Your Ref :
Our Ref : P/91/17/NMA

Application for a non- material amendment following the grant of P/125/14/PL relating to approved plans.

251 Pagham Road, Pagham, ,

FOR
CRAYFERN HOMES LIMITED
Scale : 1:100 @ A1 Date : AUG 17
Drawing No : 108_16 SK09

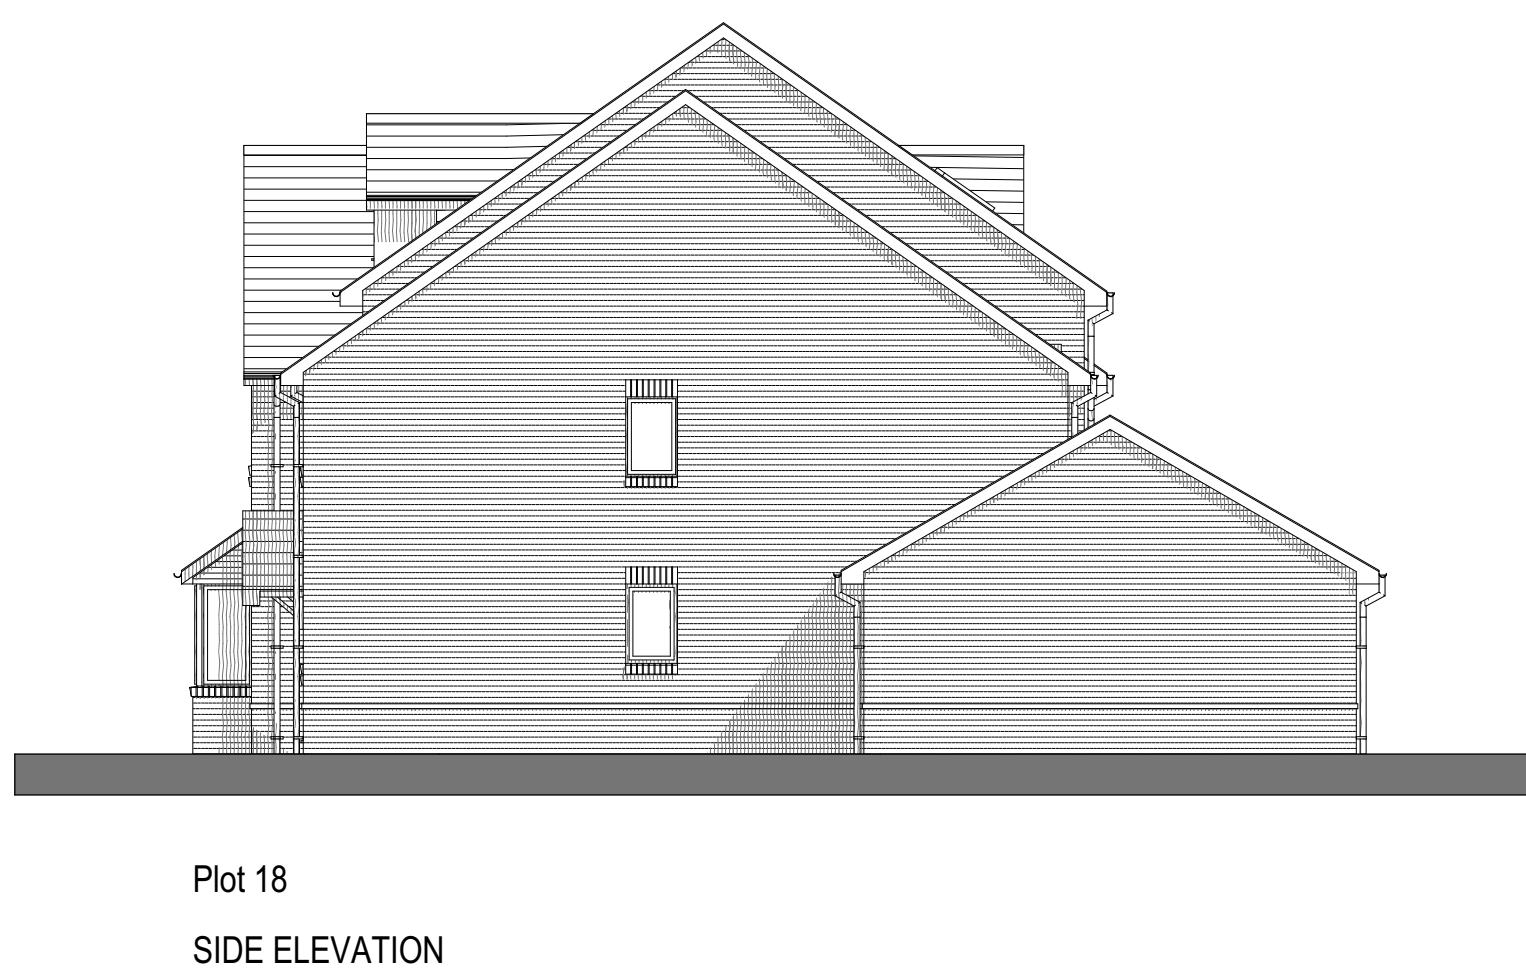
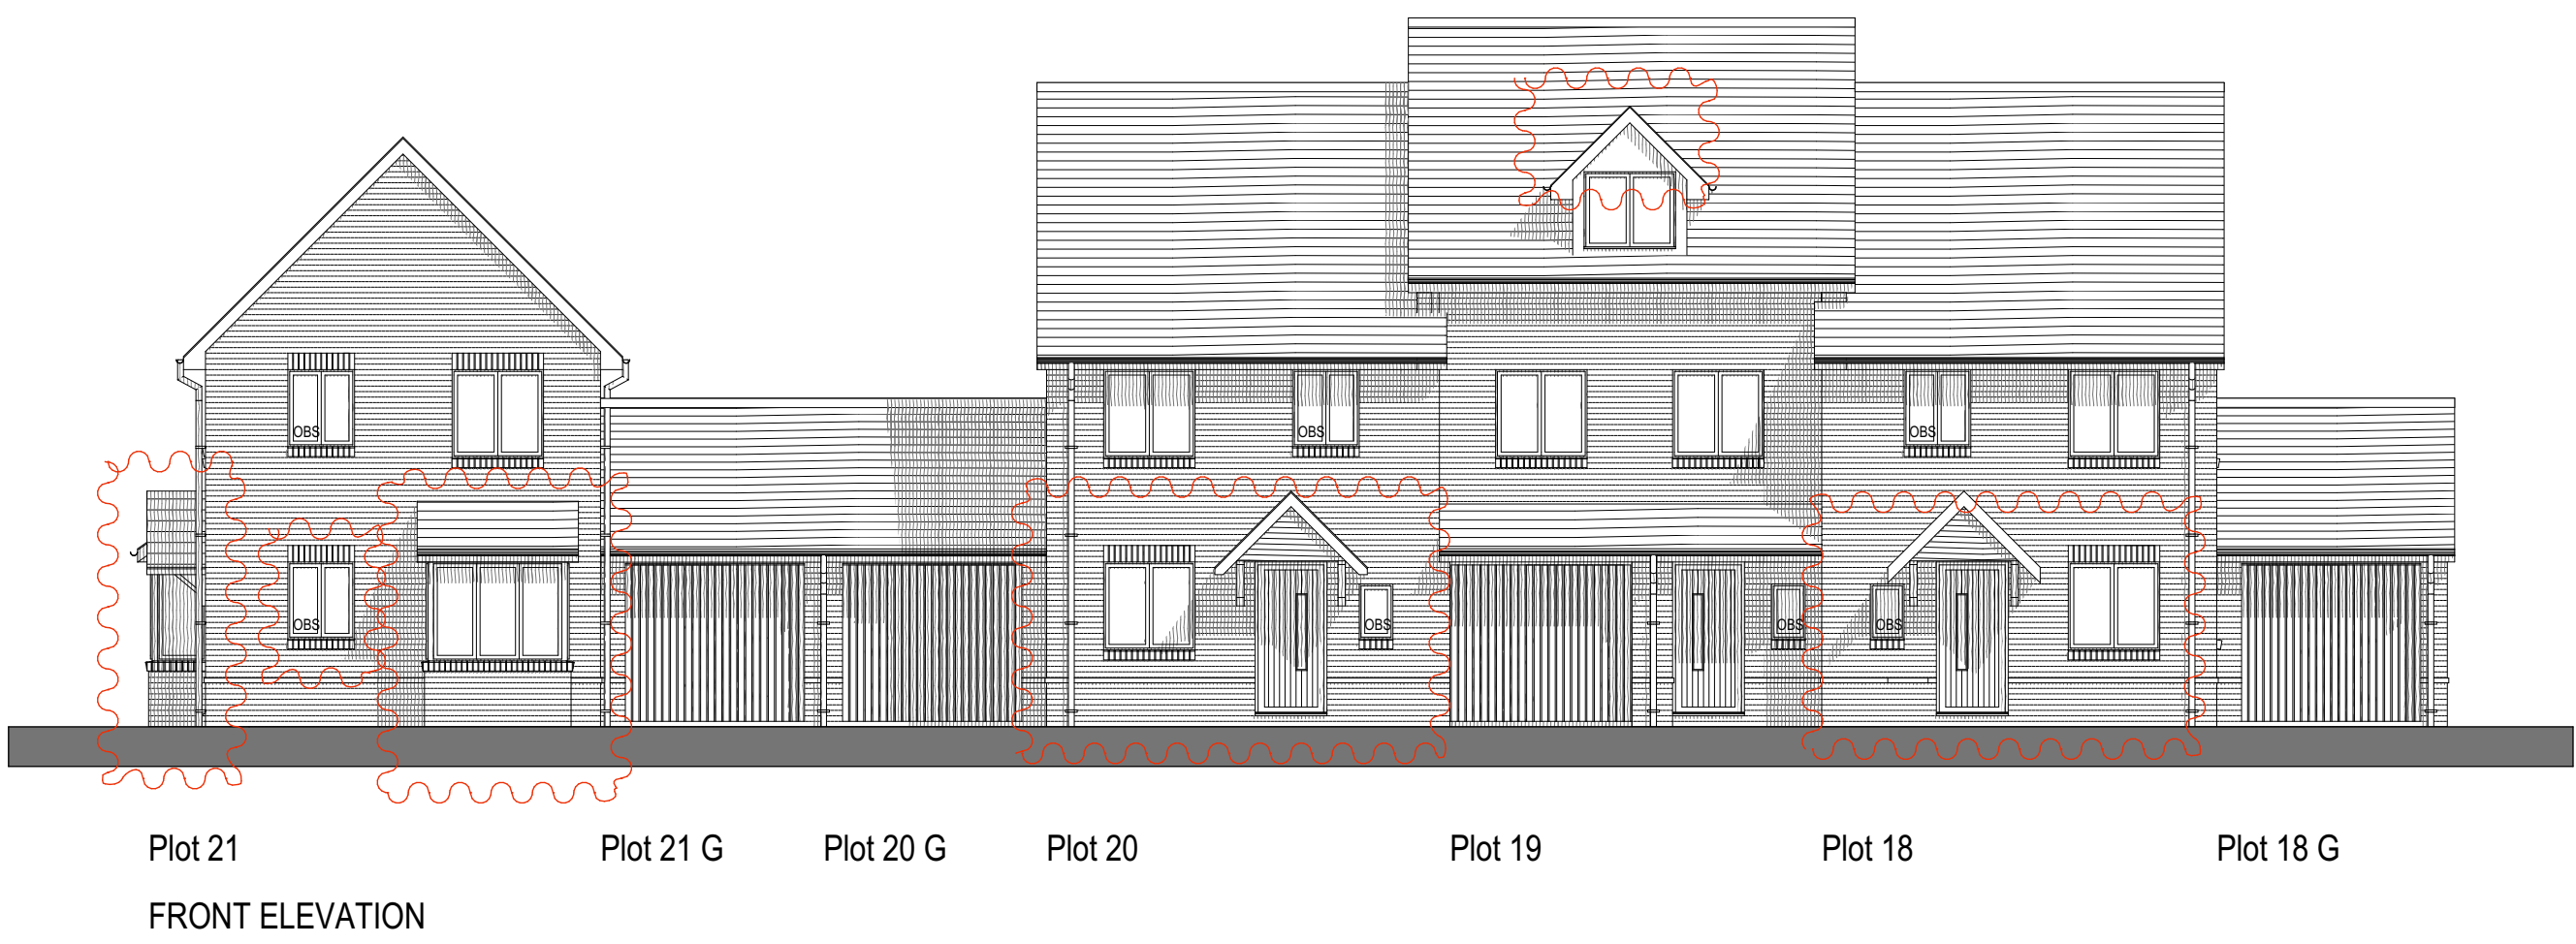
Plots 18-21 - Alteration to the shape of the bay window to no. 21 resulting in a marginal increase in footprint, alterations to the design of the design of first floor rear windows, alterations to the design of the ground floor windows & doors to the front and alterations to the design of the ground & first floor windows to one of the side elevations;

FOR
CRAYFERN HOMES LIMITED
Scale : 1:100 @ A1 Date : AUG 17
Drawing No : 108_16 SK15

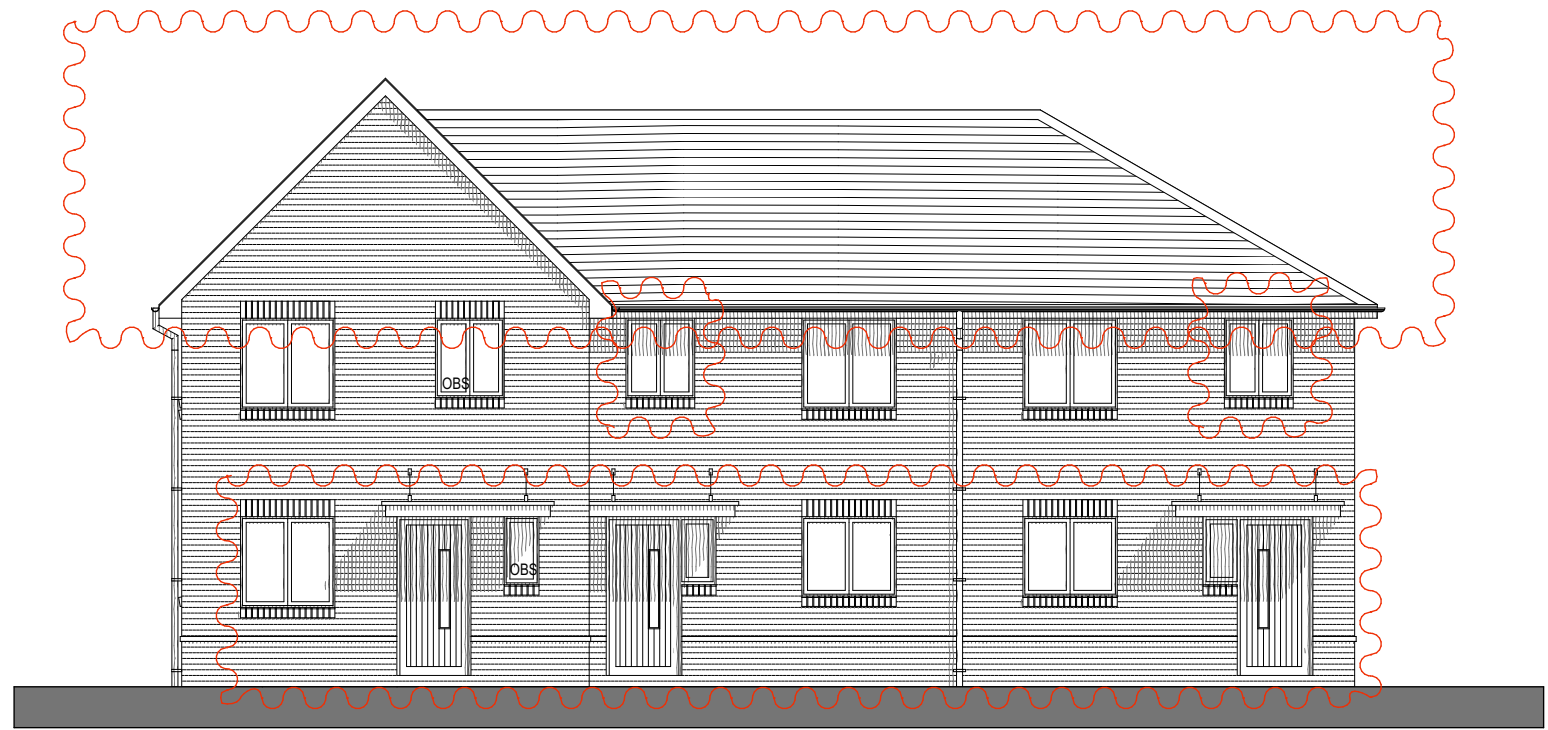
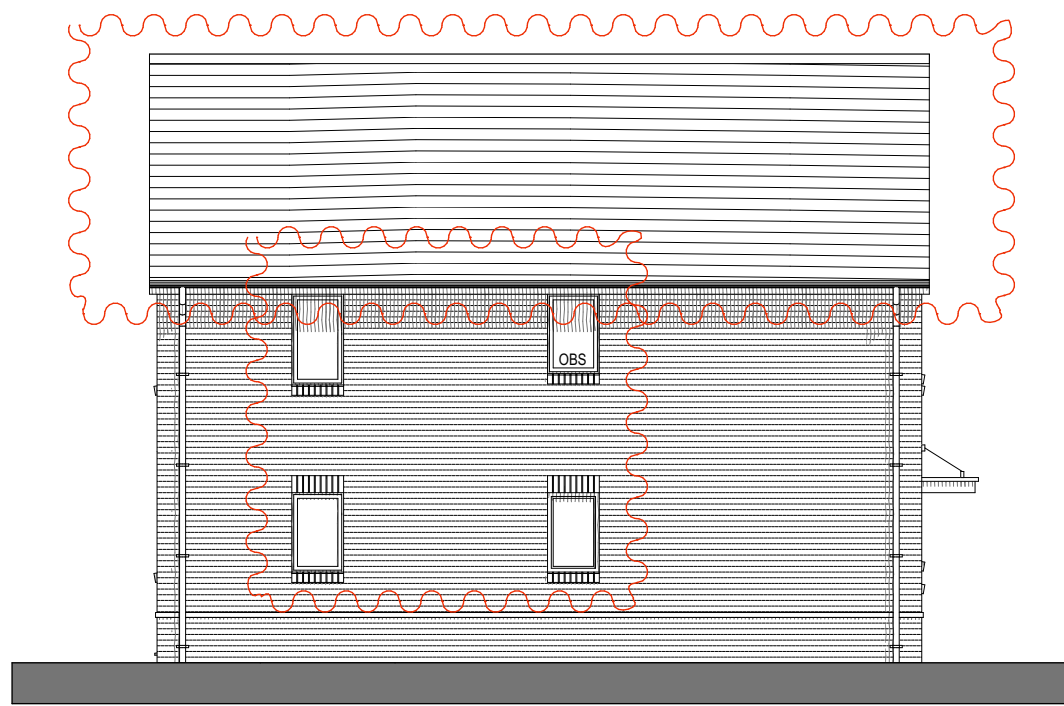
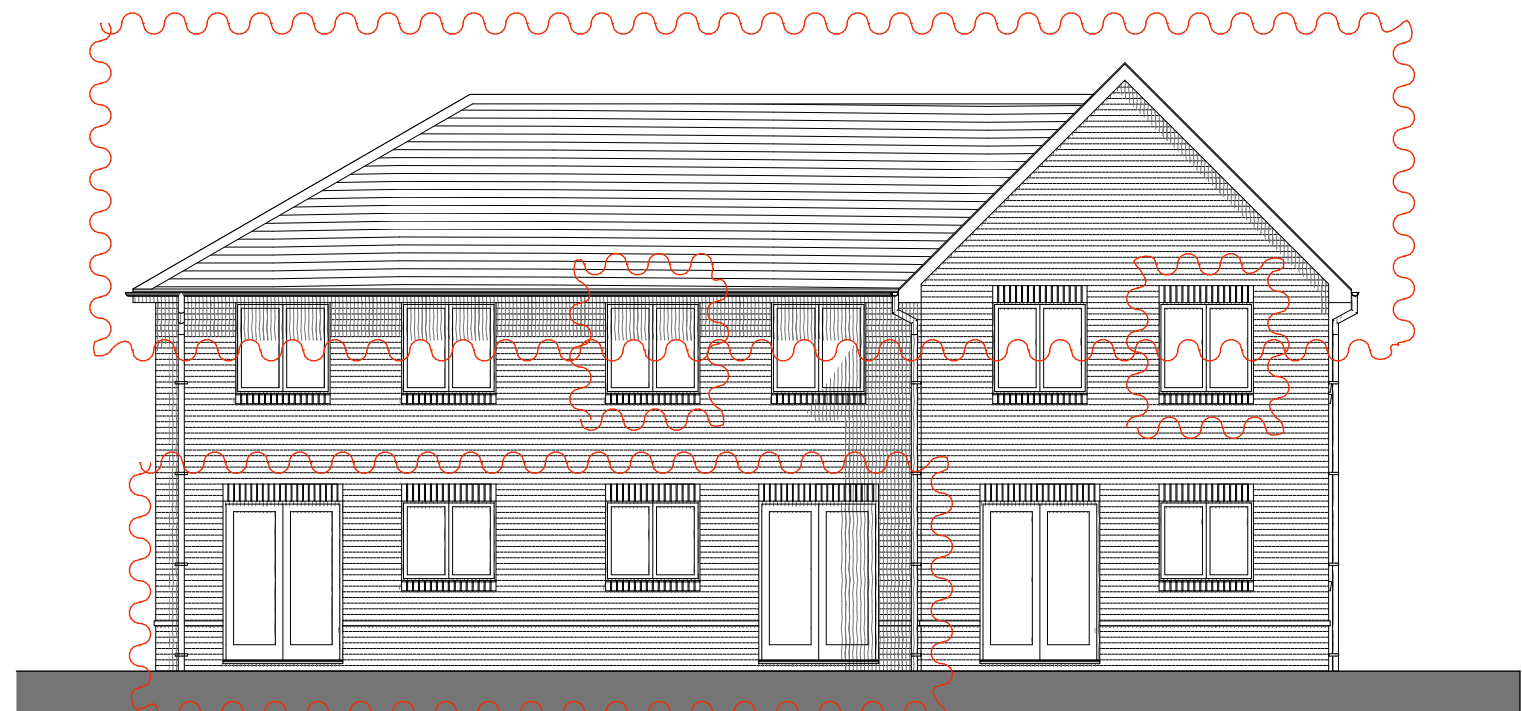
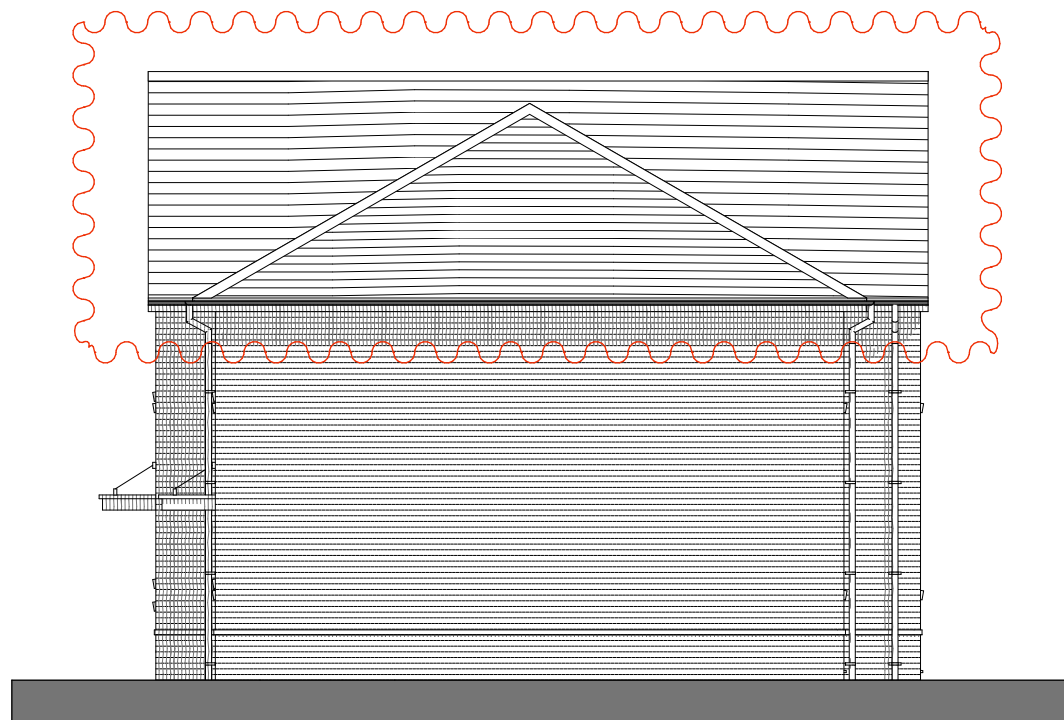
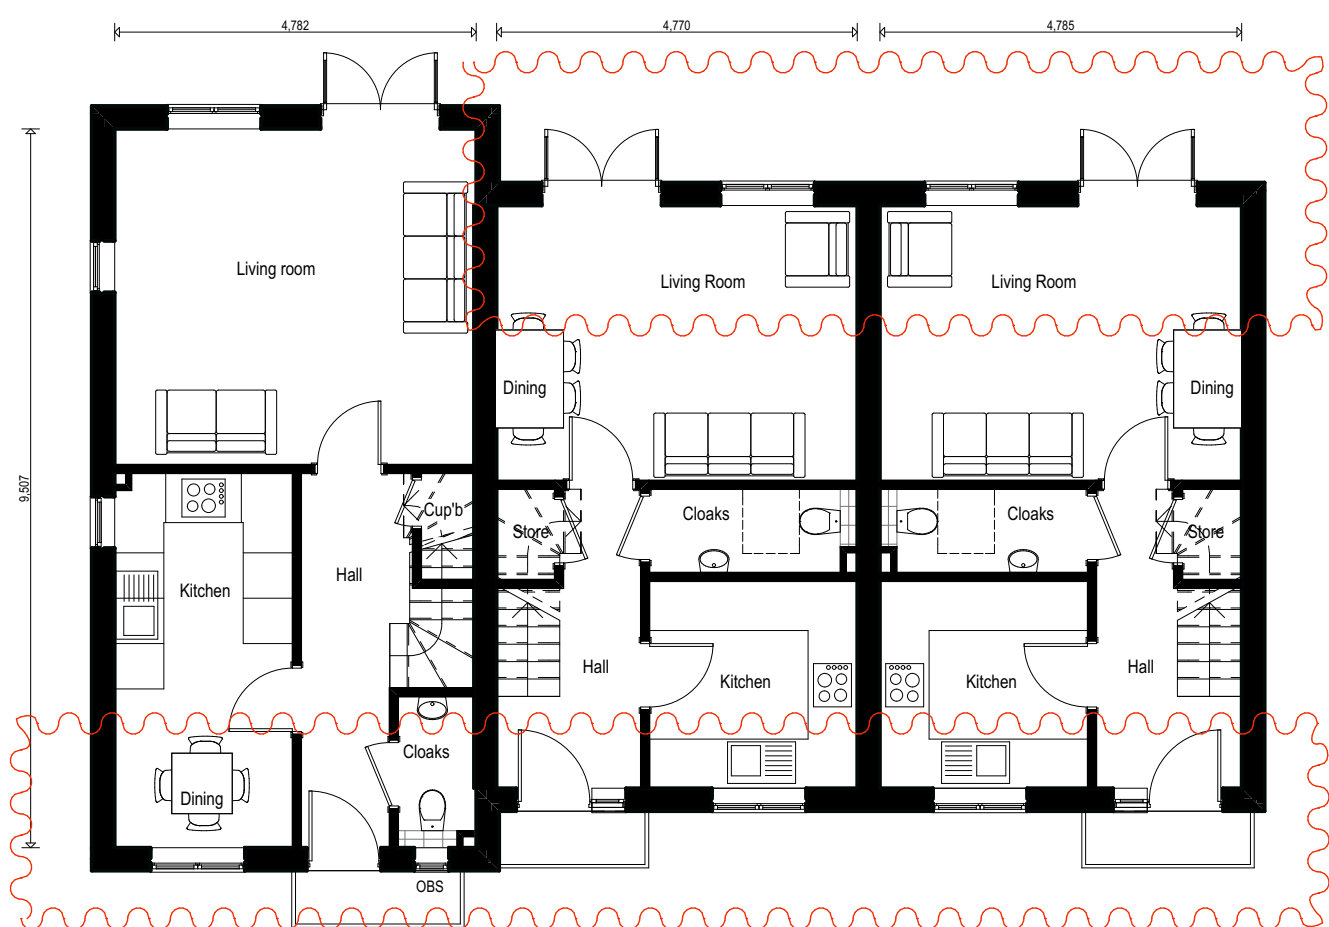
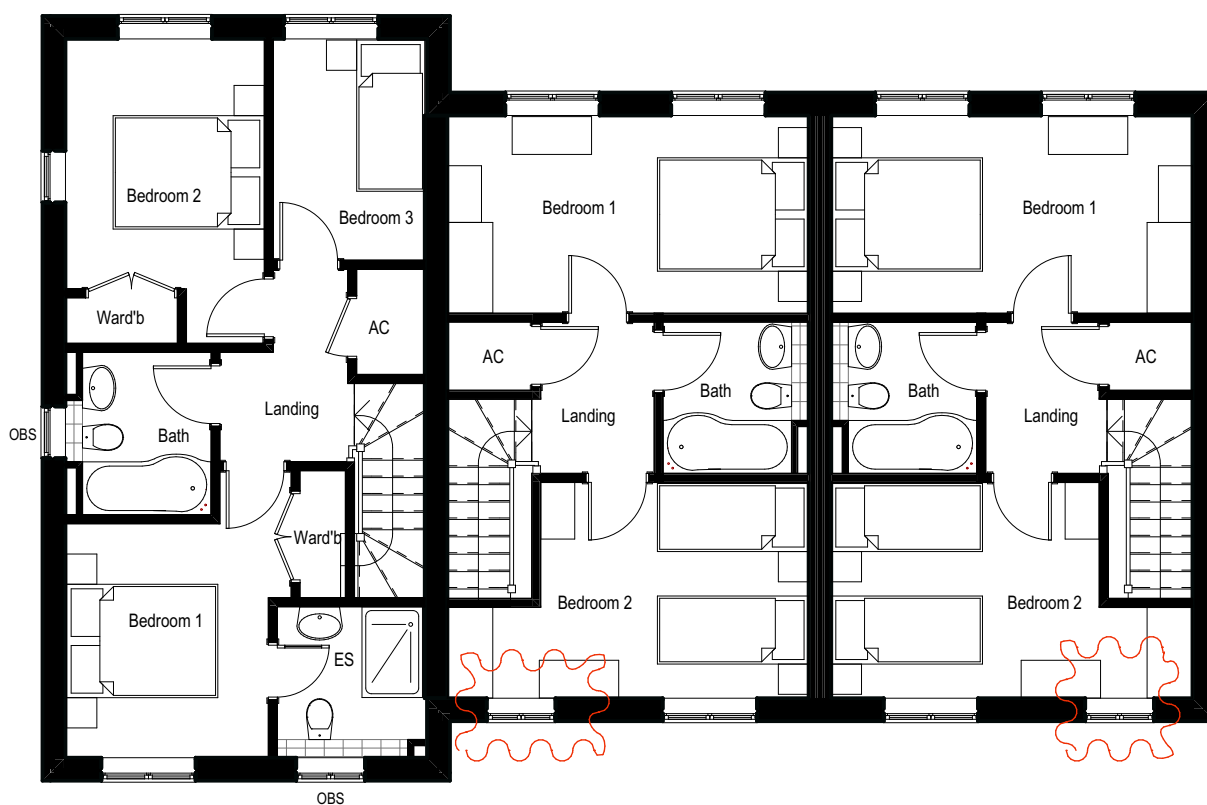
Plots 35-37 - Roof part lowered, alteration of ground floor front windows/doors, alterations to the design of one front first floor window, alterations to the design of the first floor rear windows/doors, alterations to the design of one rear first floor window and alterations to the design of the 4 ground/first floor windows on one of the side elevations; and
